PORTLAND MAINE

July 20, 2010

Re: 76 Portland Street – 036 I022 – B-2b – illegal dwelling units

2nd Floor Layout

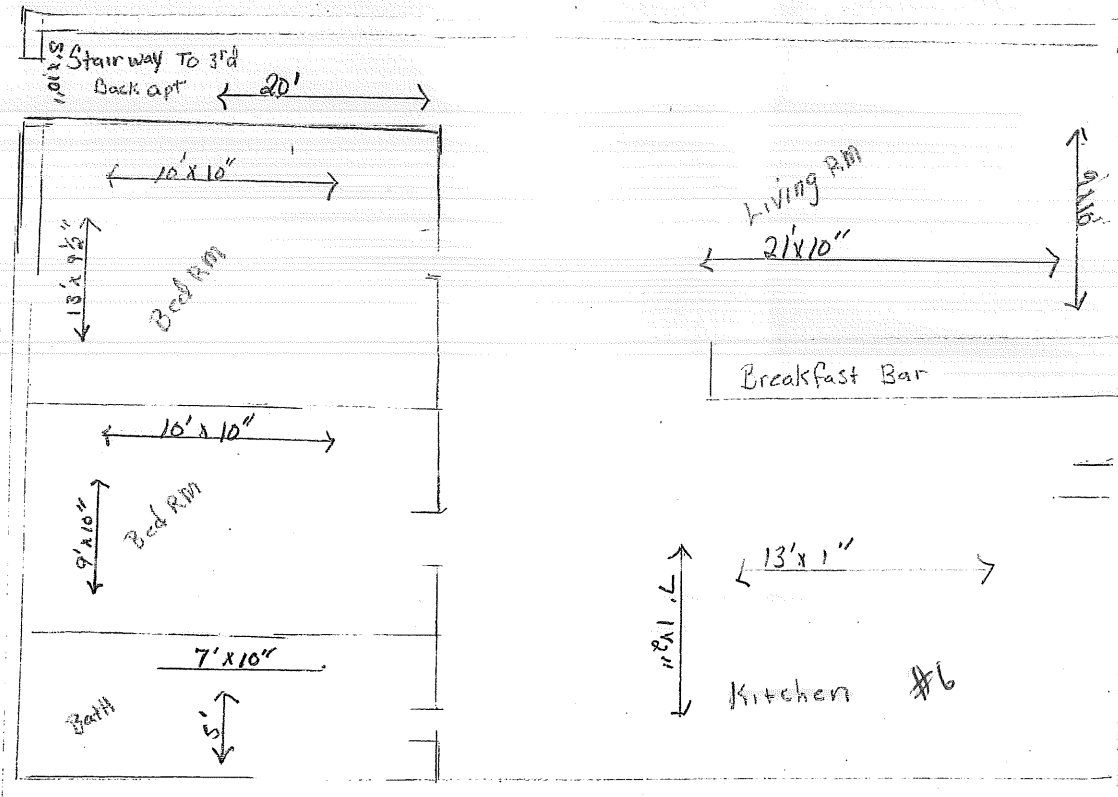
The floor plans need to be more detailed. Each floor of the building needs to be drawn out as one big plan showing where each of the individual commercial or residential units are located in relation to each other on each floor. The dimensions for each unit need to be totally clear, and the rooms within the residential units should be labeled (kitchen, living room, bed room bathroom etc.). Common hallways and stairs need to be included.
